ADDENDUM NO. 6, MAY 14, 2009

RE: Ocean Avenue Elementary School  
Portland, Maine  
A/E Comm. No. 3316.10

City of Portland RFP No. 7109  
BGS project No. 723

FROM: WBRC Architects-Engineers  
141 Preble Street  
Portland, Maine 04101  
Tel: (207) 828-4511

SHEET TITLE	331610-AE103-A
WBRC JOB FILE	331610
SCALE	AS NOTED
PROJECT NUMBER	MEJ
DRAWN BY	MEJ
CHECKED BY	MEJ
SHEET NO.	1
PROJECT NAME	AE103-A

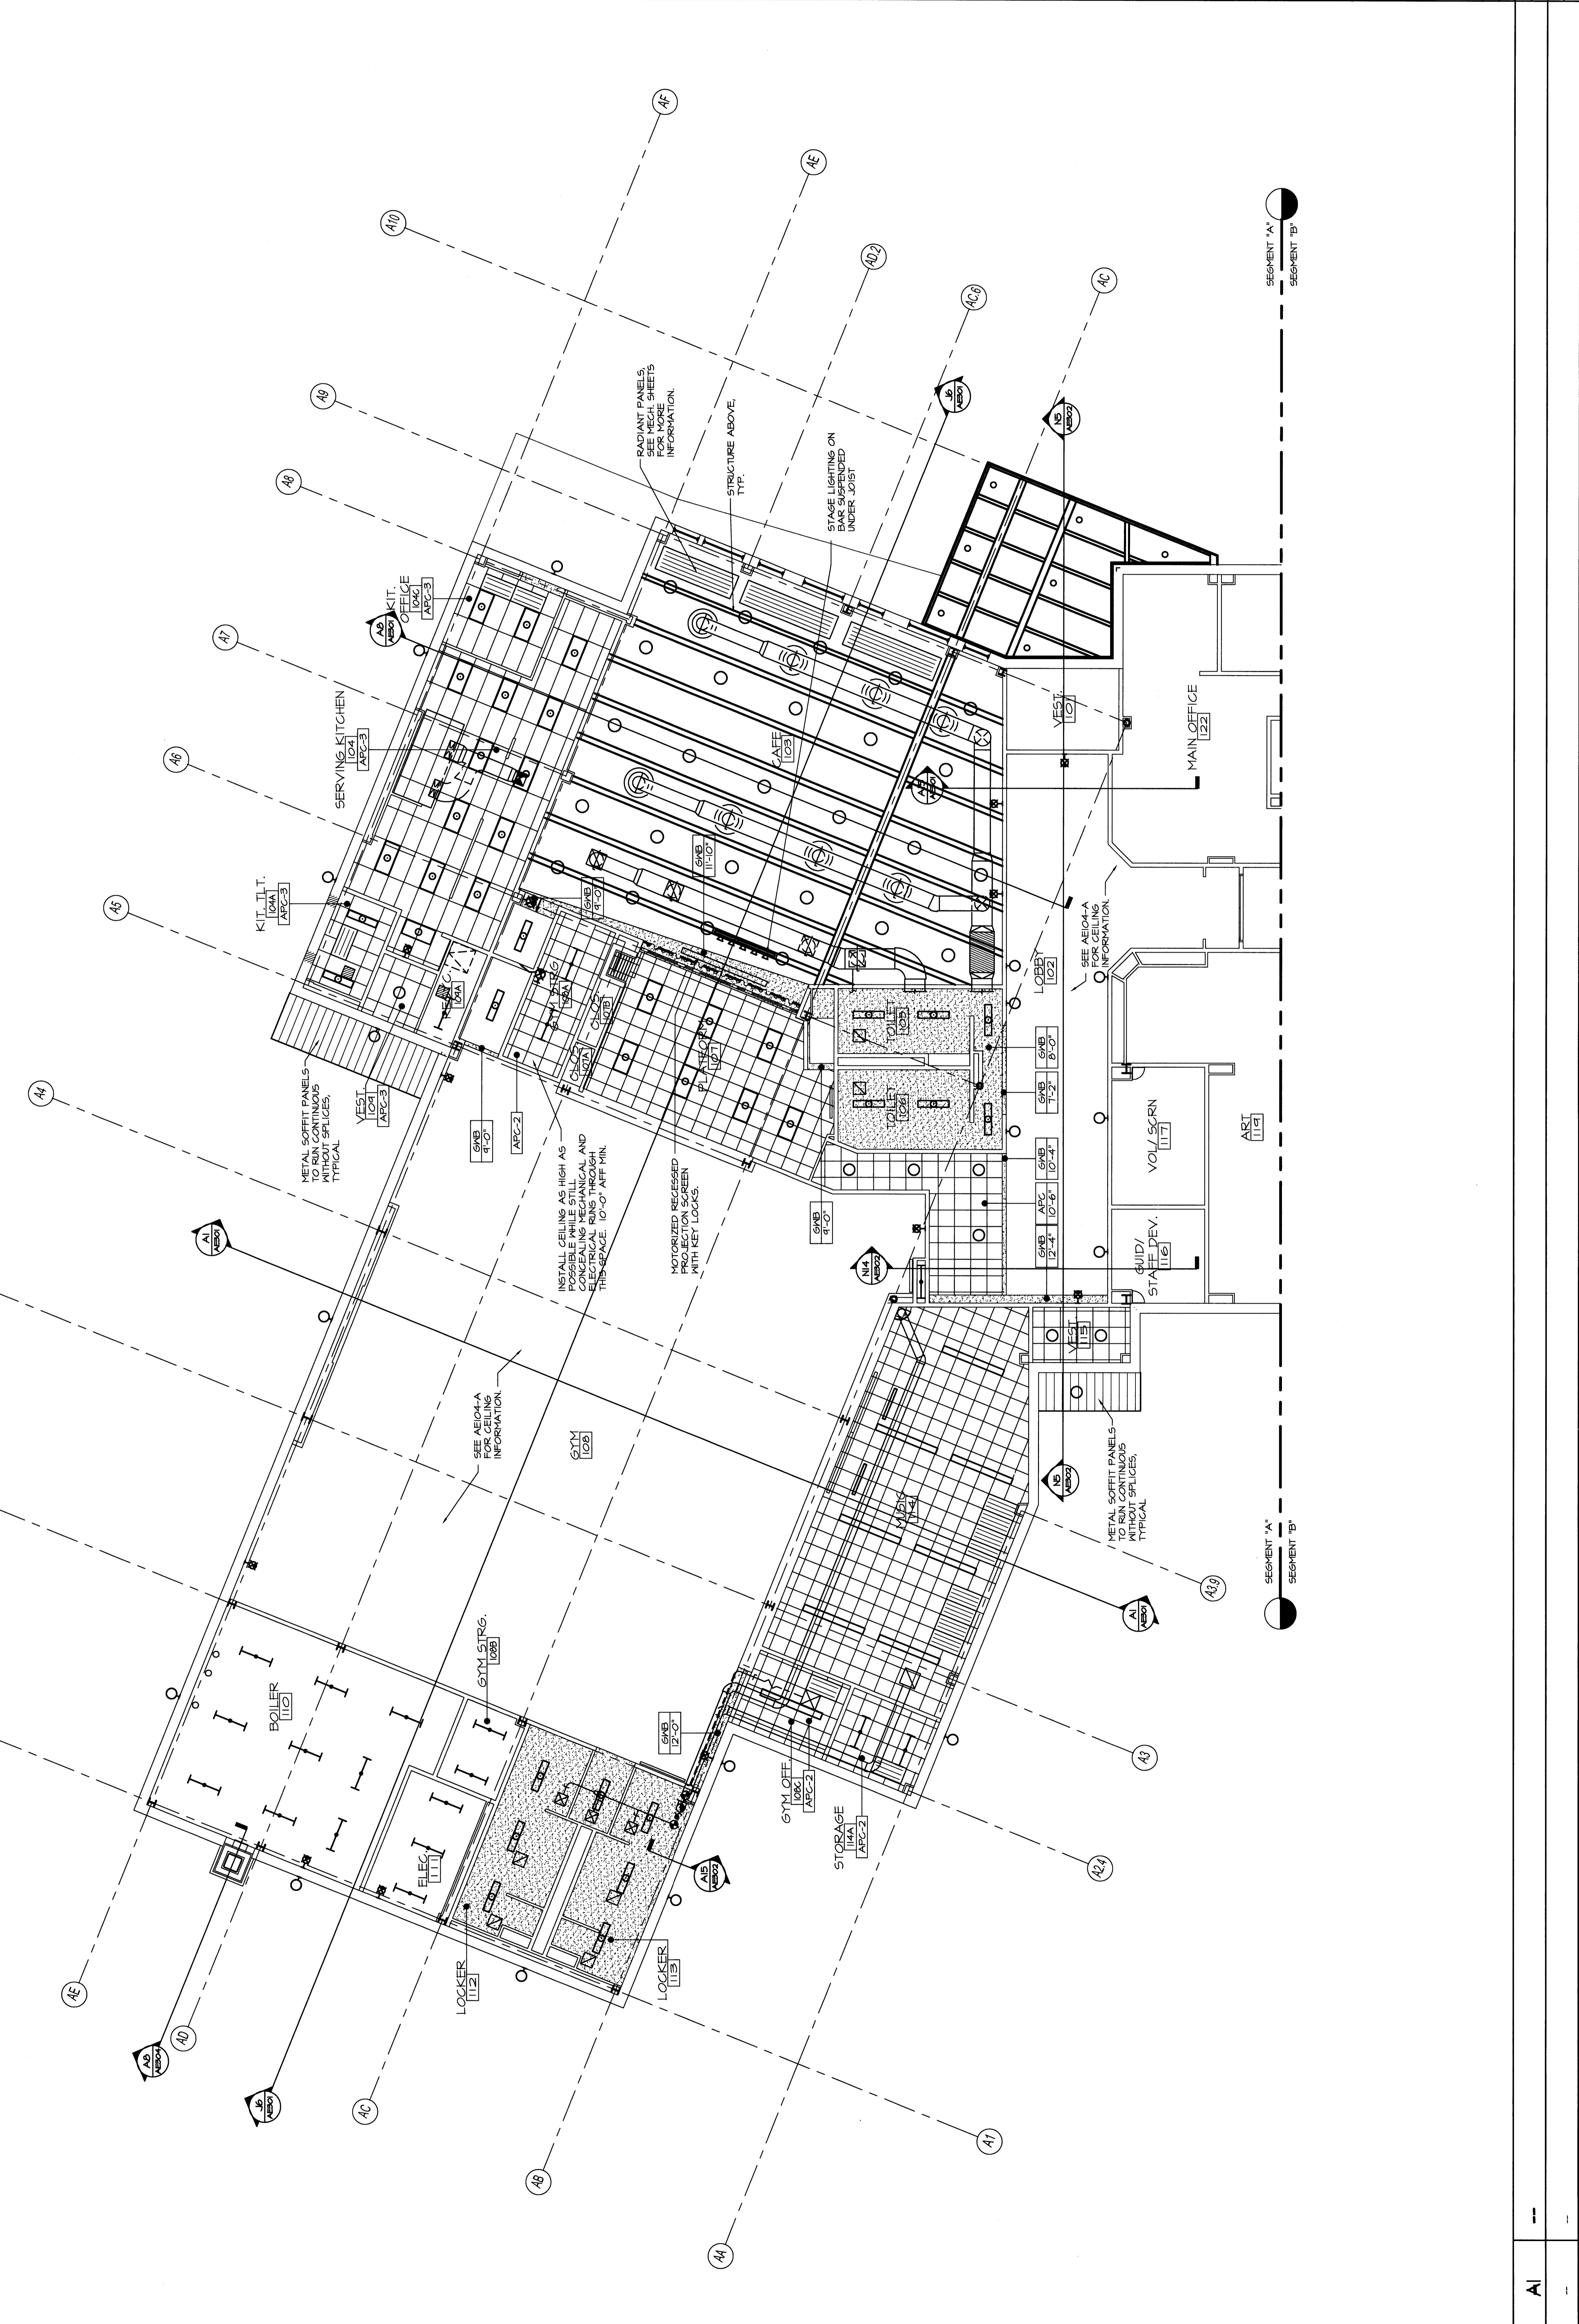
11. Sheet AE601, Door and Frame Schedule and Types, REVISE door and frame schedule as follows: Door 108AA change door type from “I” to “A”.
12. Sheet AE103-A, First Floor Reflected Ceiling Plan Seg. A, provide APC2 at the corridor link on both sides of door 108B.
13. Sheet AE403, Enlarged Floor Plans, at Details A4 and A8, CHANGE all “Aluminum” material references to “Steel”.
